Subject: RE: #6288 Planning Consultation on: Y/88/18/OUT

Application No: Y/88/18/OUT

Site: Land North of Yapton C of E Primary School, North End Road, Yapton.

Highways England Planning Response (HEPR 16-01)

TITLE: PROPOSED EXTENSION TO A27 YAPTON LANE RIGHT TURN		SCALE @ A3: 1:1000	CHECKED: MC	APPROVED: TW
PROJECT: LAND EAST OF TYE LANE WALBERTON		FILE REF: ITB11324	DRAWN: AB	DATE: 23.05.17
CLIENT: WATES DEVELOPMENTS		DRAWING No: ITB11324-GA-014		
		PROJECT No: ITB11324		REV: C

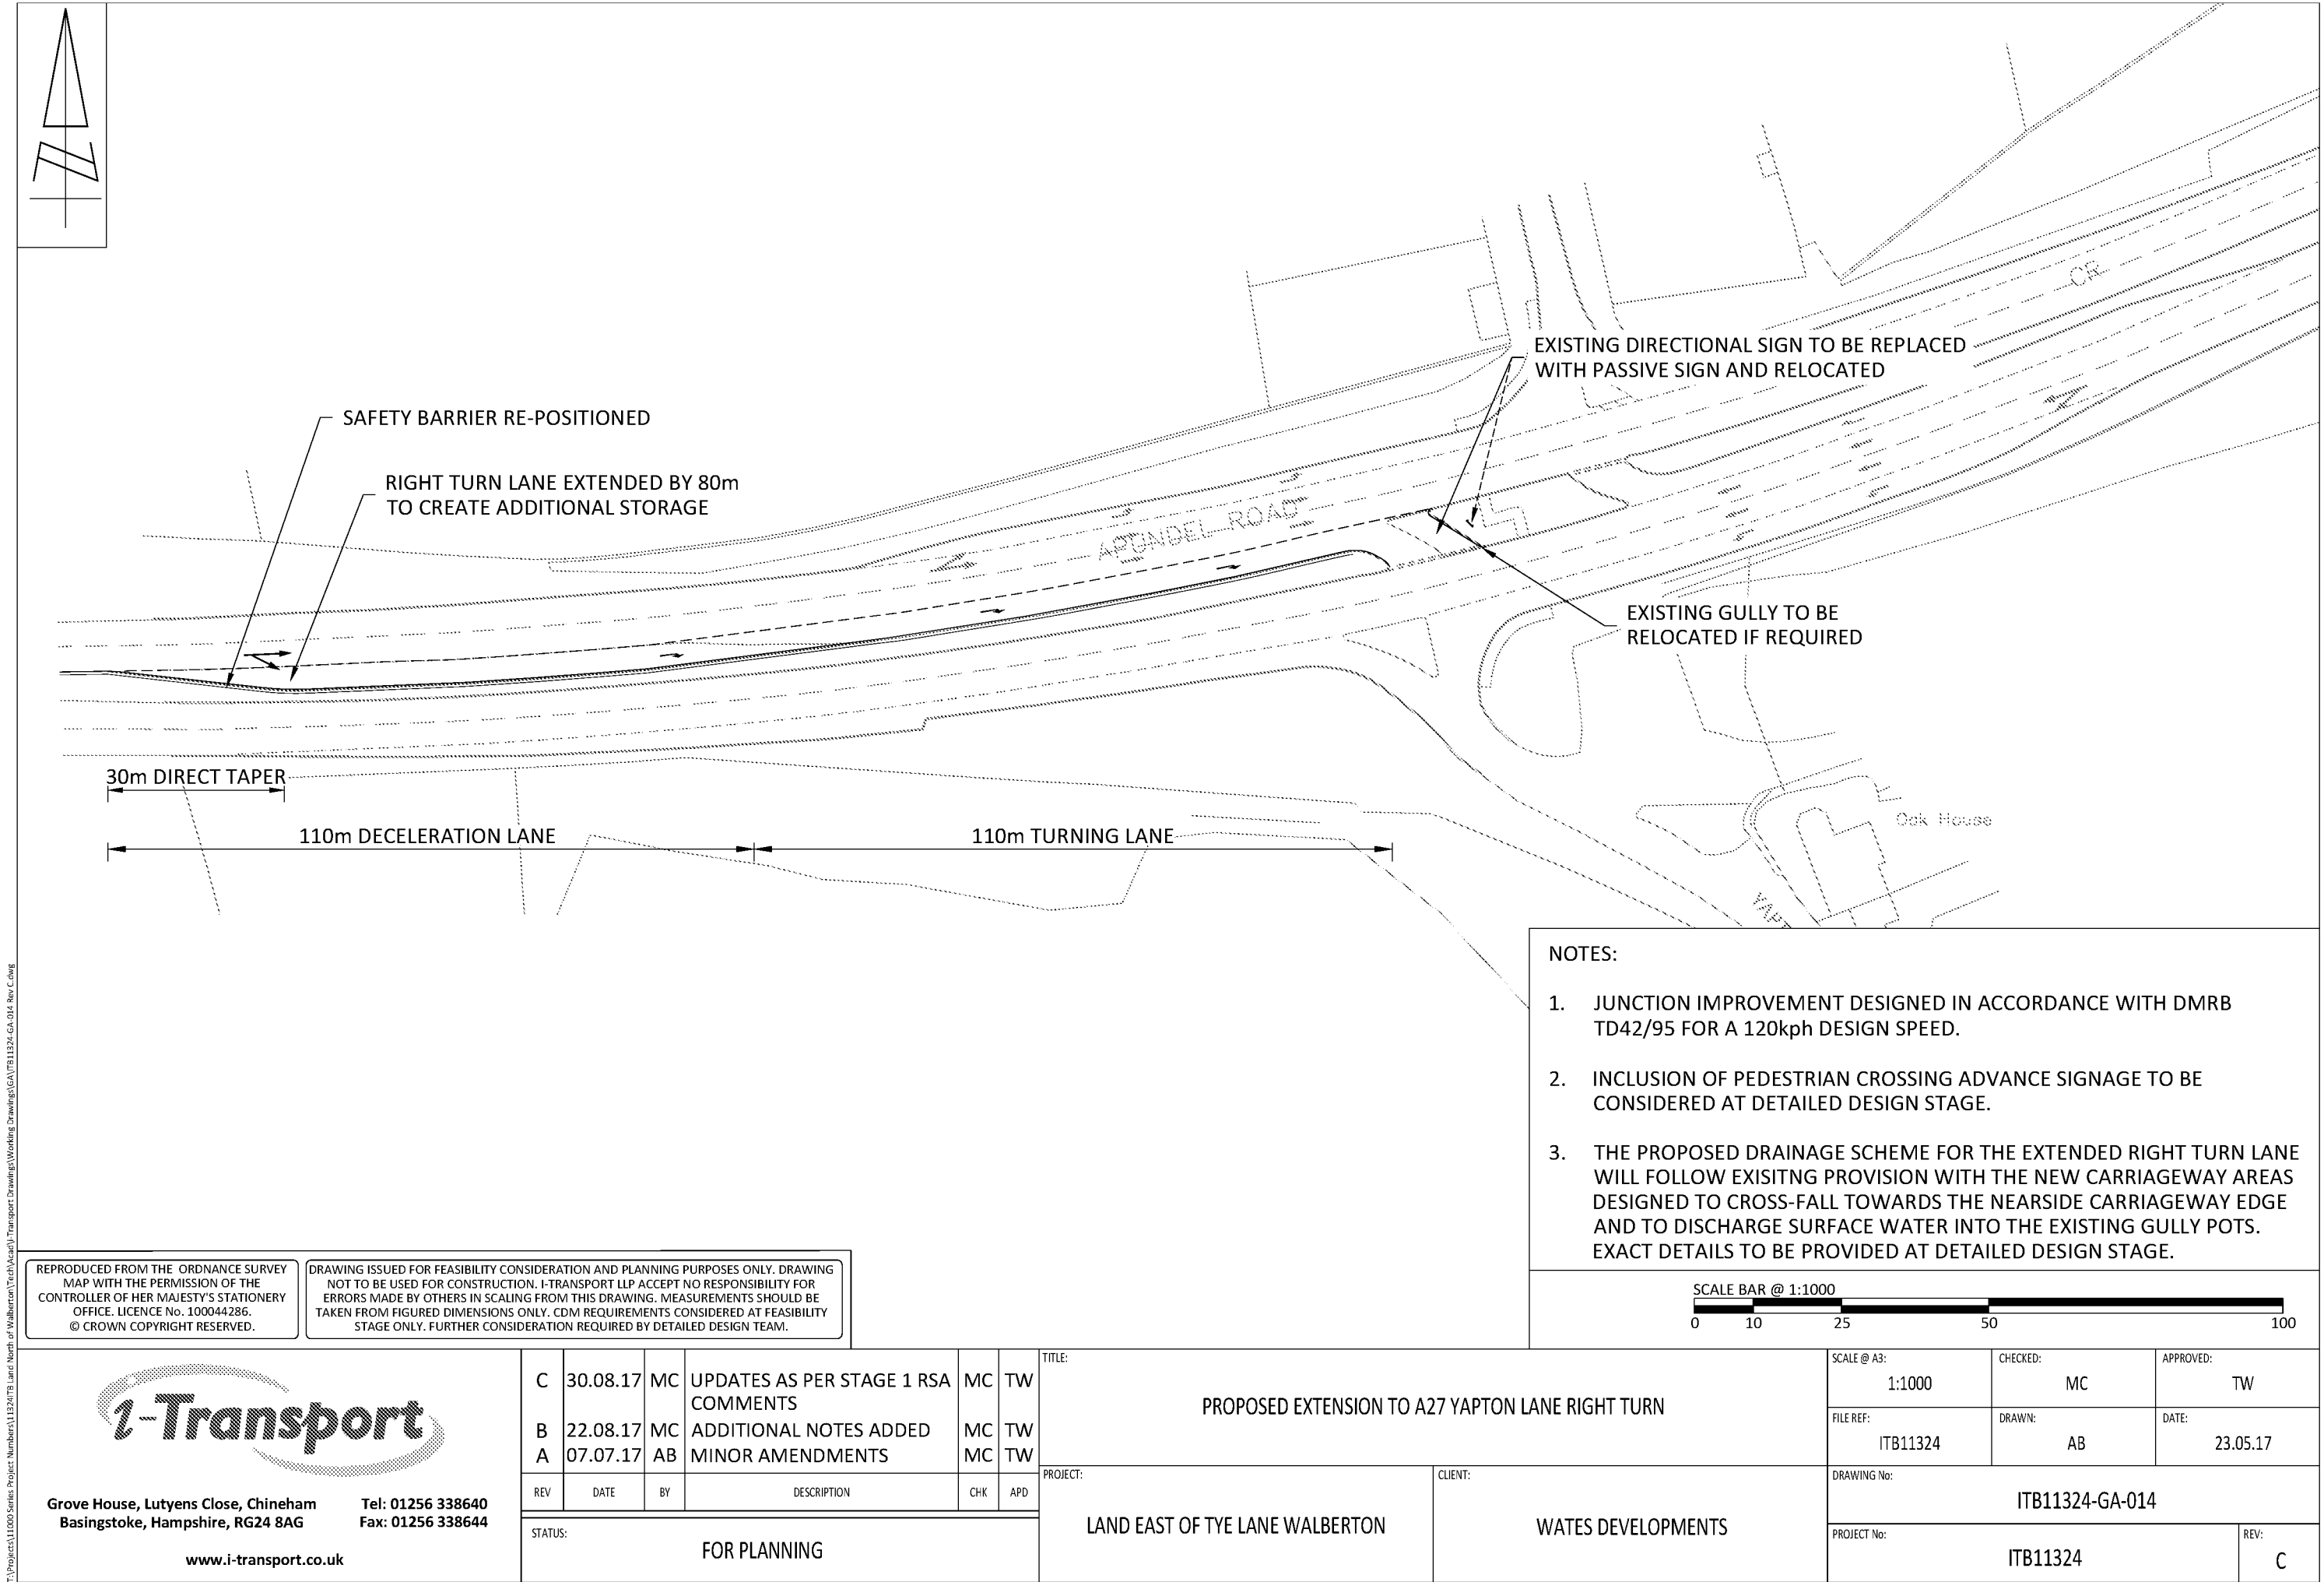
- 1) Prior to the occupation of 20th dwelling within the development hereby permitted, the improvement works at the A27 / Yapton Lane junction shall be completed and open to the travelling public as shown on i-Transport's drawing number ITB11324-GA-014 Revision C "*Proposed extension to A27 Yapton Lane right turn*" dated 30/8/17.
